Sydney Metro Martin Place

Over Station Development

Design Review Panel #08

25 February 2019

Figure 1. Elevation - Hunter Street edge

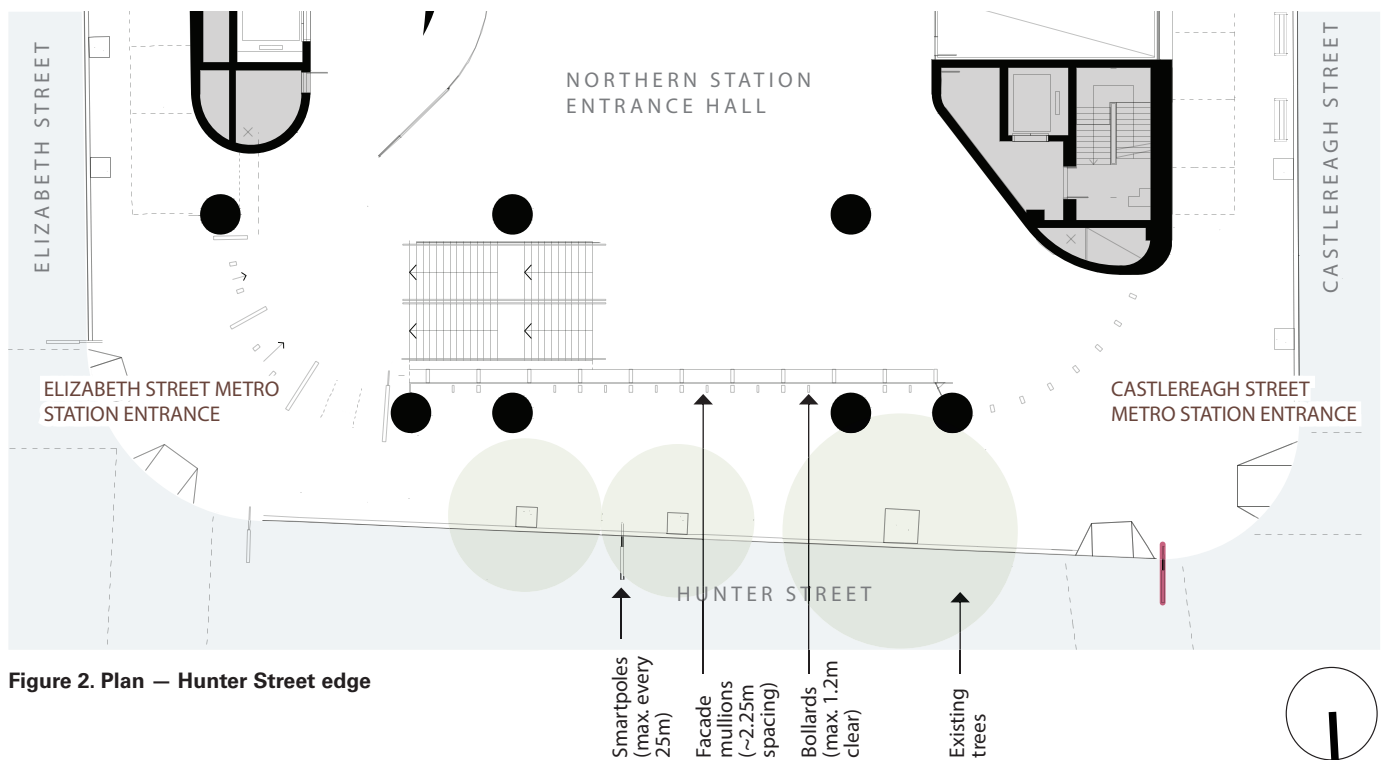
*“While the proposal for stairs creates a more welcoming corner entrance, the building’s interface with Hunter Street is unresolved. We are **concerned about the spaces between the building and columns** on the northern elevation.”*

*“We recommend consideration of **opportunities for public seating** between the columns on the northern elevation to Hunter Street.”*

“The areas between the columns and footpath to Hunter are not optimised and lack a positive civic presence.”
